Arun District Council
Arun Civic Centre
Maltravers Road
Littlehampton
West Sussex BN17 5LF
Planning & Building Control General Enquiries
Tel: (01903) 737756 Fax: (01903) 730442
Dx: 57406 Littlehampton
Minicom: 01903 732765
e-mail: planning@arun.gov.uk
website: www.arun.gov.uk/planning

Application No: FP/224/20/HH
Site Address: 57 Minton Road Felpham PO22 7JX
Description of works: Two storey side and rear extensions to existing dwelling & replacement of existing front loggia.

Thank you for your internet representation made on 3rd January 2021 which has been recorded as an objection with the comments as follows:

DRAWING
**ELEVATIONS
PROPOSED**
DRAWING No
323/05A
REVISION
SCALE 1:100
DATE DEC 2020
DRAWN LA
CHECKED

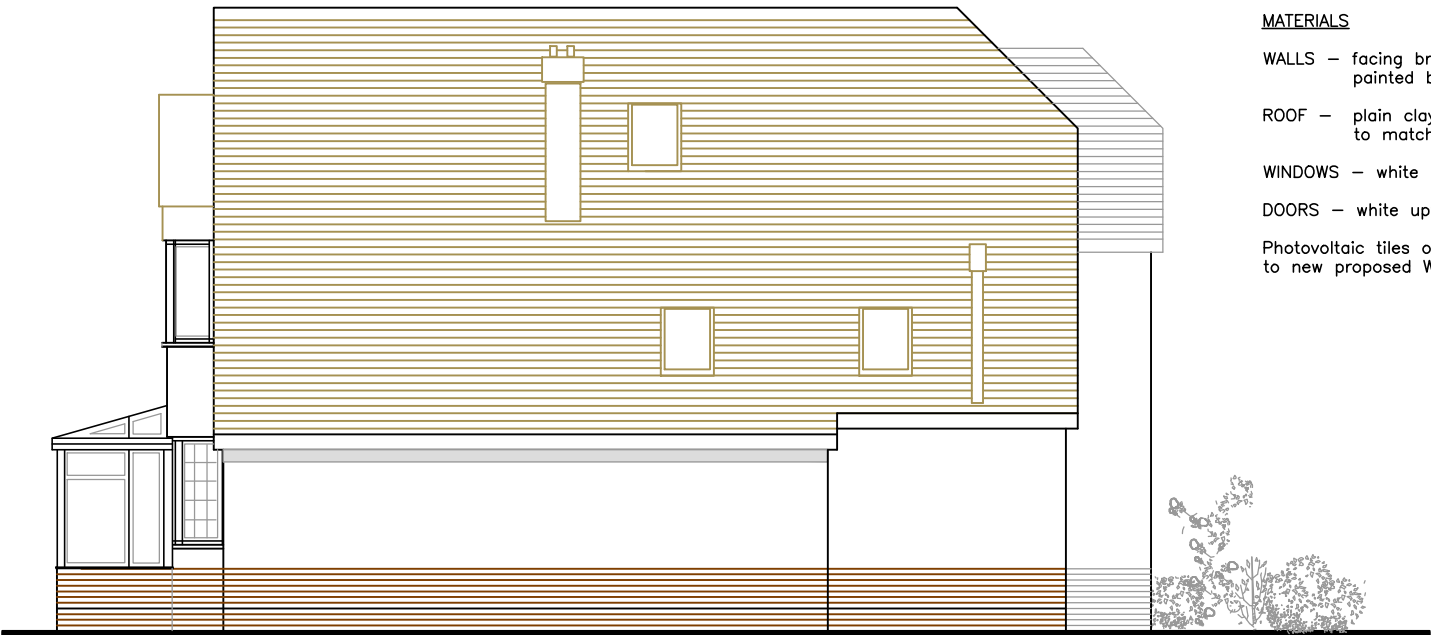
I am commenting on the amended plan, which was posted as I submitted my previous comment. The changes made in the amended plan are welcome, however, the main thrust of the previous comments still stand. The single storey extension, now 0.5m off our boundary, rises to the full height of the house and the loss of light and the negative impact on the outlook from our patio area, garden and our dining/living area, whilst reduced, will remain considerable. The loss of light in the study will be unchanged by the new plan. Although slightly reduced in size, the overall plan is still considered too large and impactful (in depth) although having amended (doubled) the gap between 55 and 57 to 1.8m there would appear to be some scope to extend more laterally and further reduce the depth (and the negative impact) of the extension thus also gaining useful garden at the expense of the "wasted" space between the properties. The amended plan only affects part of the proposed extension and therefore the open aspect of the rear of the properties will remain adversely affected.
